Paterson Licensed Post Office

Martins Creek Quarry Expansion – Application no SSD-16_6612

Environmental Impact Statement.

Drawing Title
MARTINS CREEK QUARRY
DUKE STREET / KING STREET, PATERSON -
INTERSECTION MEDIAN WORKS

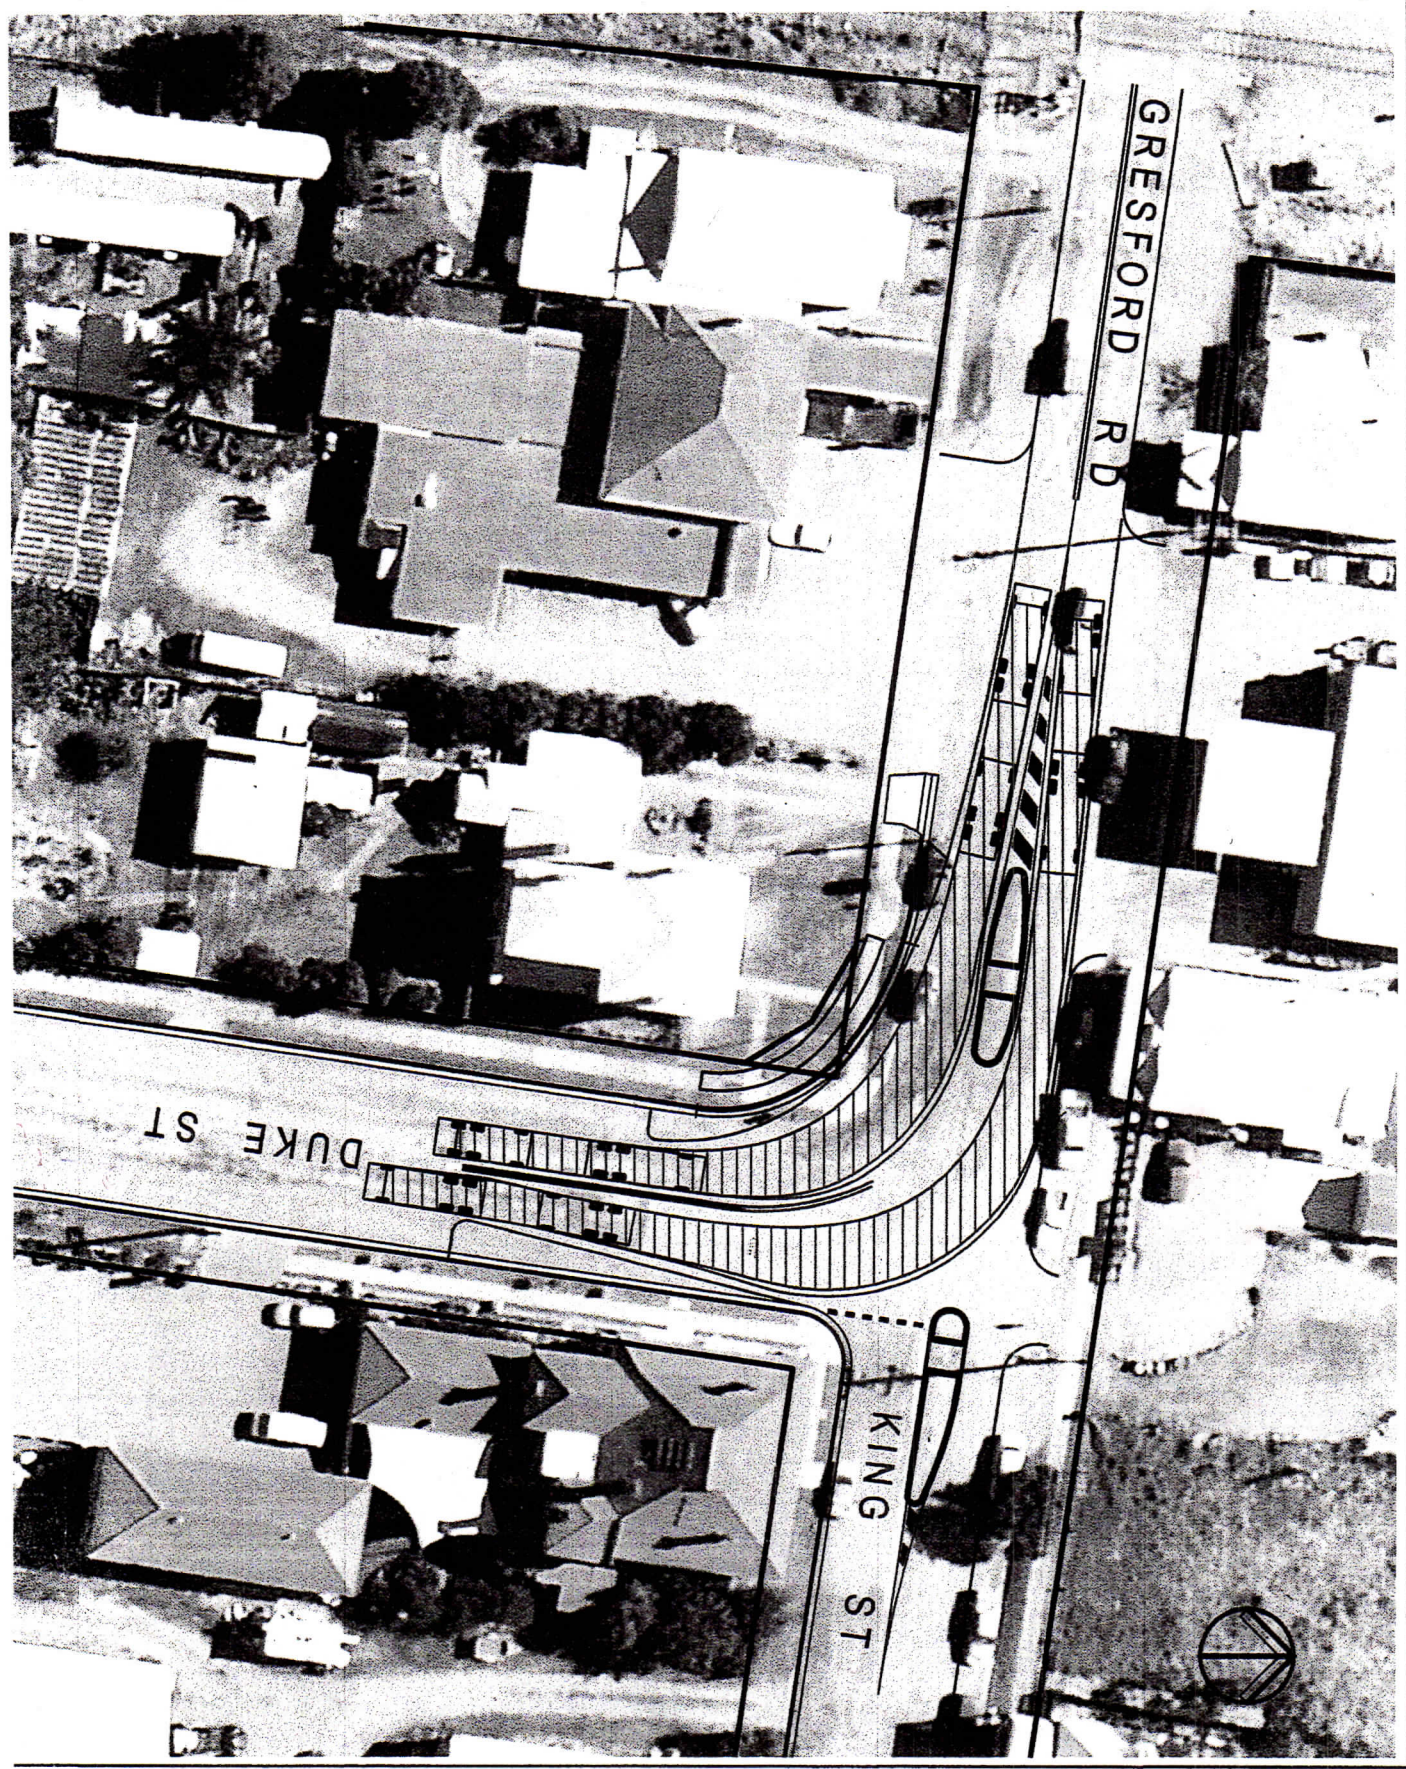
In the impact document it mentions the 90 degree bend at either Gresford Road/Tocal Road or Gresford Road/Duke Street – in the figures document it shows Gresford Road/Duke Street. This is deceptive as Gresford road actually starts up the other side of the railway. The intersection is King and Duke Streets and shows that the applicant and report author has used google maps for a base and drawn lines on it, probably having not left their office or bothered to check.

Note: no mention of pedestrian crossing in second version and no provision shown on street diagram.

In the Engineering & Transport Assessment Figures report – page 10 - we see Daracon's plans for the intersection of King Street and Duke Street in the village of Paterson. This diagram came as a complete shock to us and if it comes to fruition would have disastrous consequences for our business.

The new alignment on the corner will eradicate all parking in front of the Paterson Post Office and some at the side. It also shows that cars parked on the opposite side of King Street in front of the service station and cafe appear as being hit by trucks passing the new medium strip. This would mean people collecting their parcels, and sending items or paying their bills would be required to walk a long distance to the post office - if they could find parking. Parcels of over 10 kilos are common, with many larger sizes, e.g. saddles, wine, small white goods, the list is endless. The Australia Post contractors also need easy access to the building for drop-offs and pick-ups, these occur from 7am till 4.45pm Monday to Friday, along with couriers i.e. Startrack and Dungog Parcel Service. Also Australia Post organises a security pickup by Armaguard each week- where will they park? The special 10 minutes parking, which is in front of the Post Office would disappear, nowhere is it mentioned about the planning of this. Also on this corner is a telephone box and 2 telstra cable pits - would they need to be removed/relocated ?. The public telephone is an absolutely essential service - please don't say everyone has mobile coverage, in Paterson we don't - we have been told we are in the next rollout, every year. The local member recently said he had heard something was happening in the future, but not what year. Previous members for the district have stated they have said something in parliament etc, etc.

Nowhere in the document does it say about the amount of car parking spaces to be removed. It might surprise people, not only cars, but horse floats, caravans, trailers, cattle transports, and many others require parking, it still is a rural community. The parking in King Street will be also impossible, as the plan shows, the cars already parked will be run over by the trucks especially the 10 min drop off point. Many senior residents need parking in this area, with the Chemist, Doctors, Newsagent, Post Office and Service Station being impacted on. No mention is made in this document, only about trucks from the quarry, do the people not exist after this matter is rubber stamped, does the town now not exist. There is NO detail about how this is going to happen or timeframe or even talking to the businesses who will suffer by this proposal. How can the greedy applicant dictate that it must profit from expansion and strangle the long established businesses in Paterson.

The pedestrian refuge is very dangerous as the 80 trucks an hour, how would one get across the road anyhow. The concrete (I gather that what it is) again no mention what the lines are for would force the trucks to go wheel to wheel, see diagram Appendix H shows the truck tyres meeting as they go around the corner at the side of CBC Bed and Breakfast and the Post Office. Putting in concrete blocks and removing parking will be a quick death for the Paterson businesses. A historical
